December 20, 2019

**RE: US Eagle FCU – Juan Tabo  
1955 Juan Tabo NE  
Grading and Drainage Plan Stamp Date: 11/21/19  
Hydrology File: H21D029**

Based on the submittal received on 12/16/19, the Grading and Drainage Plan cannot be approved until the following are corrected:

SHEET NUMBER:
C-101

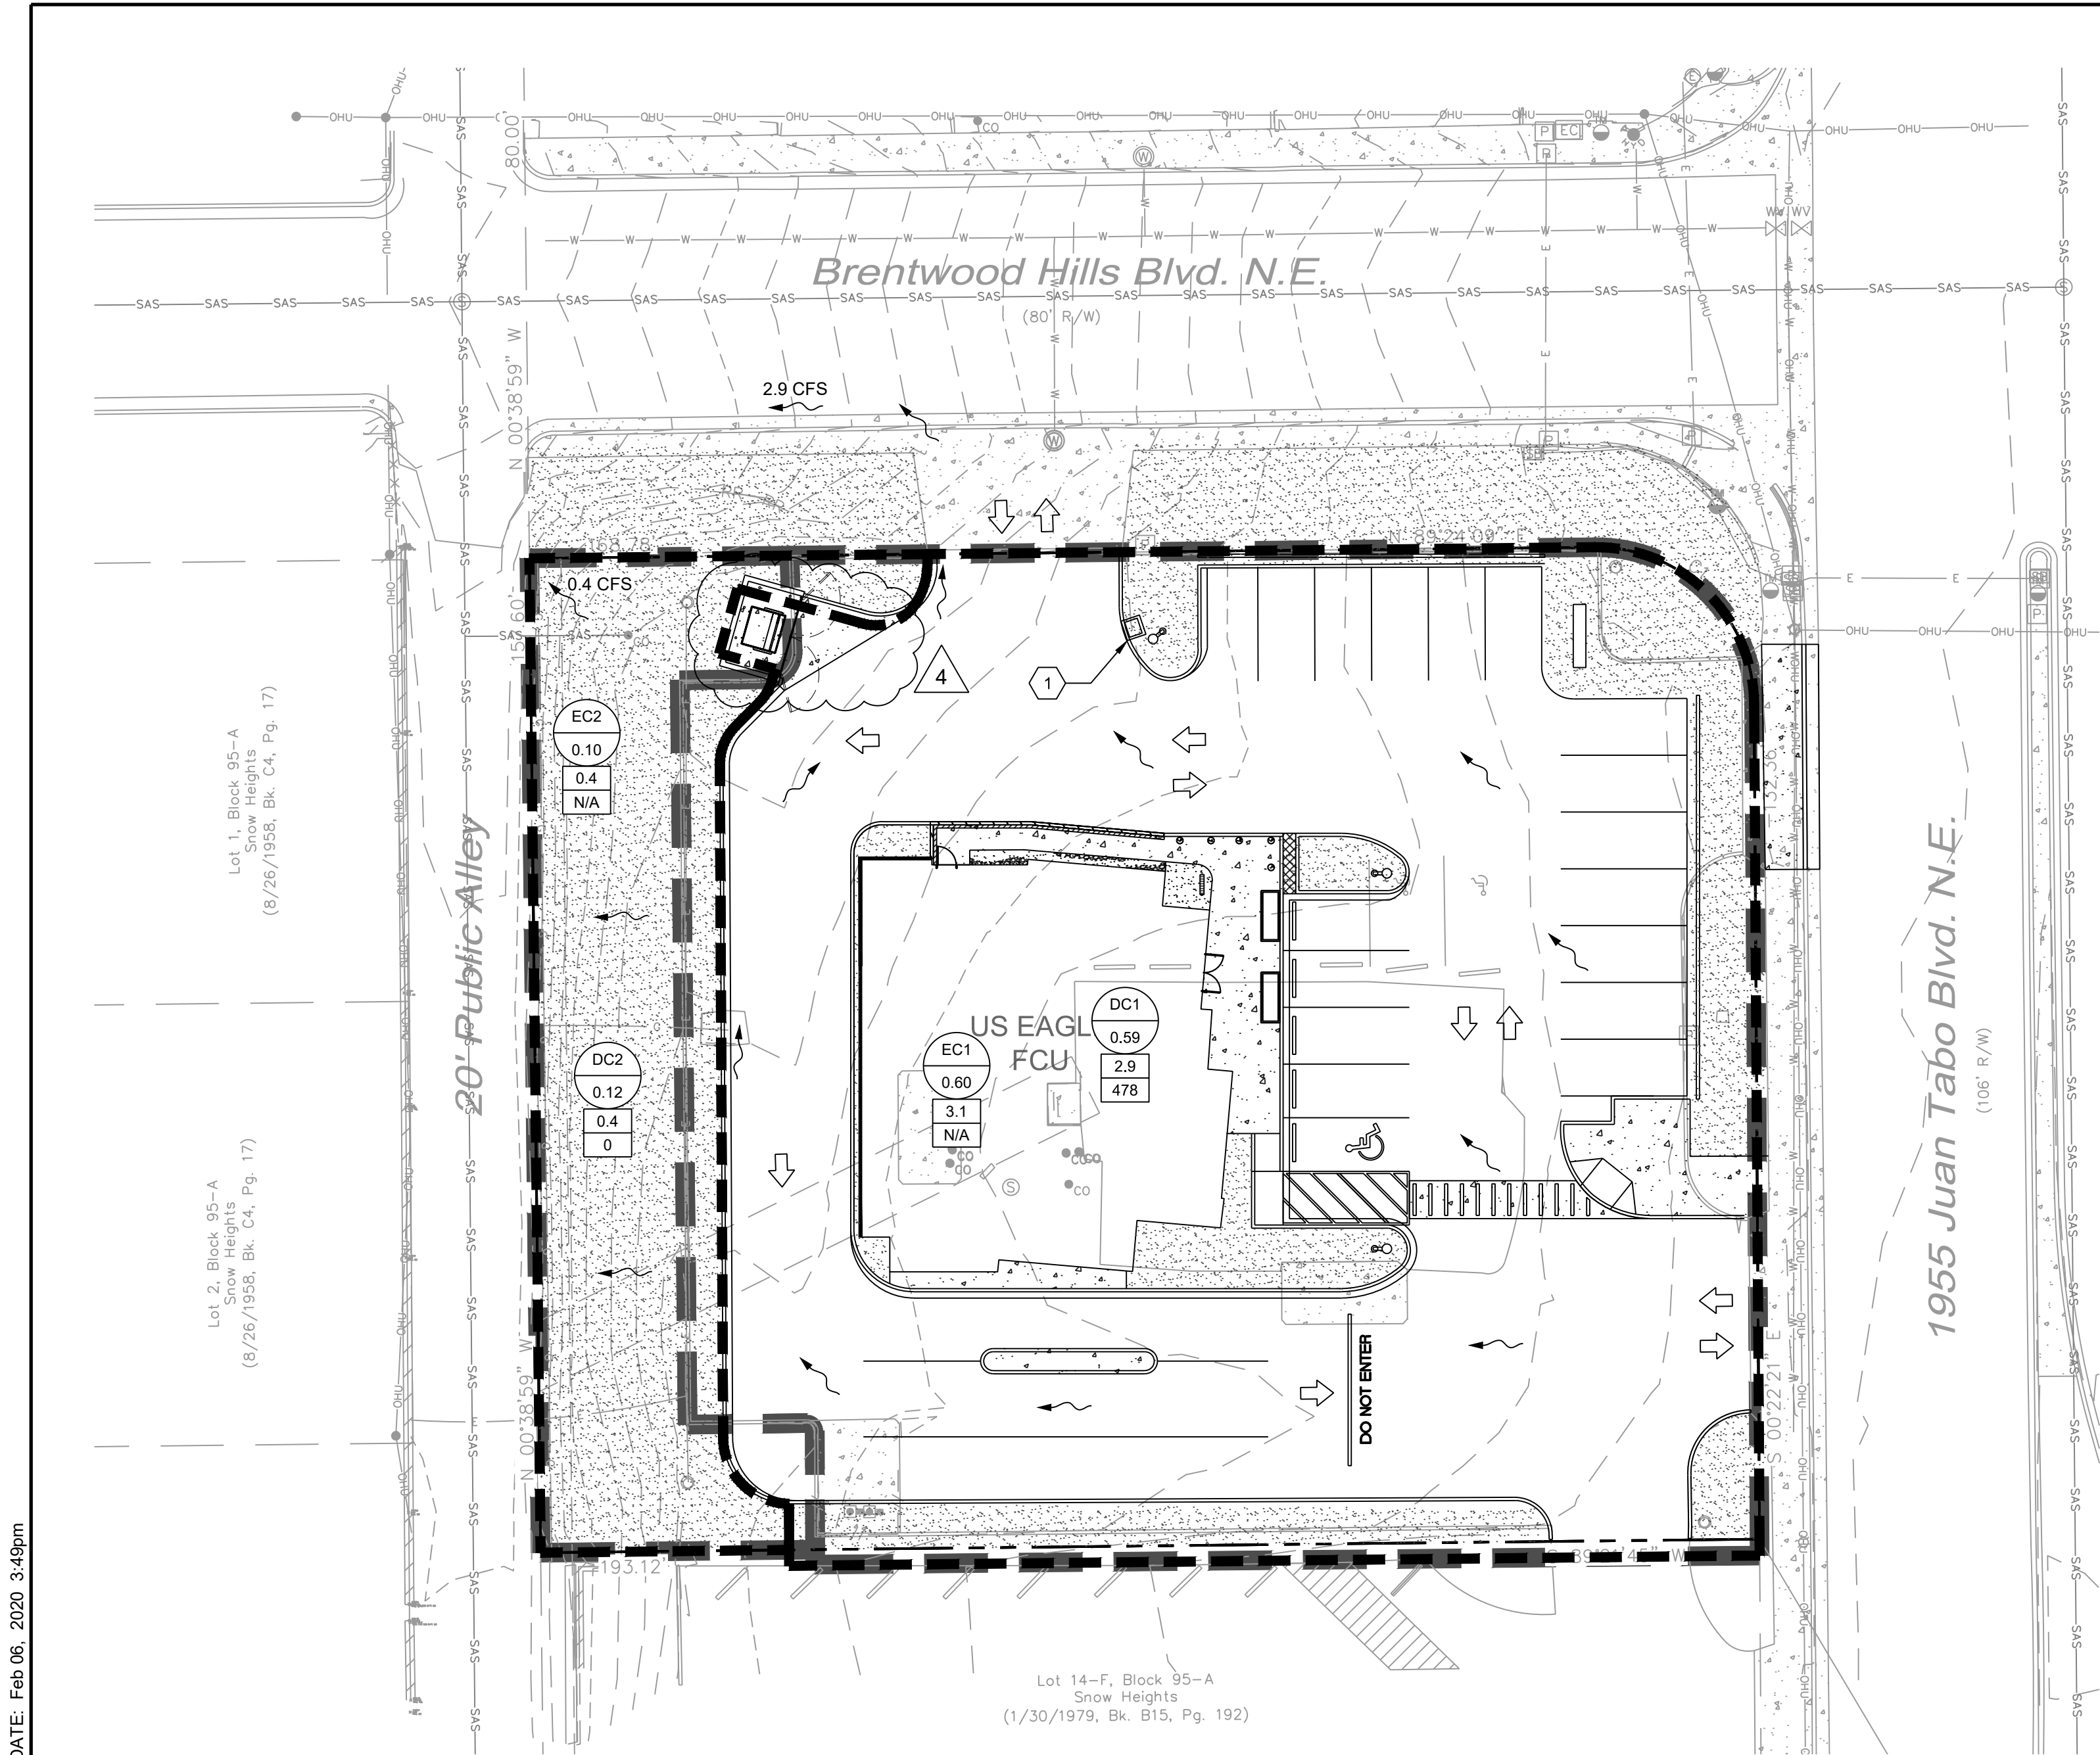
1. This site qualifies as redevelopment and is only required to retain runoff from the 80<sup>th</sup> percentile storm ( $\text{Vol.} = 0.26'' * \text{Imp. Area}$ ); calculations need to be corrected to reflect this.
2. A waterblock, 0.87' high, per COA Paving Detail No. 2426, is required at the driveway entrance (Juan Tabo side).
3. Show the grading and paving for rebuilding the alley.
4. If only seeking Site Plan for Building Permit approval at this time, label the grading plan "Conceptual, Not For Construction" or similar and address the SPBP comments. If seeking SPBP and Building Permit simultaneously, forgo the conceptual markings and address all SPBP and Building Permit comments.

5. Payment in Lieu (Amount =  $481\text{CF} \times \$8/\text{CF} = \$3848$ , per sheet C-101) of onsite management of the SWQV must be made. Take three copies of the treasury deposit slip to the Treasury and then include one copy of the paid deposit slip when resubmitting.
6. As a reminder, if the project total area of disturbance (including the staging area and any work within the adjacent Right-of-Way) is 1 acre or more, then an Erosion and Sediment Control (ESC) Plan and Owner's certified Notice of Intent (NOI) is required to be submitted
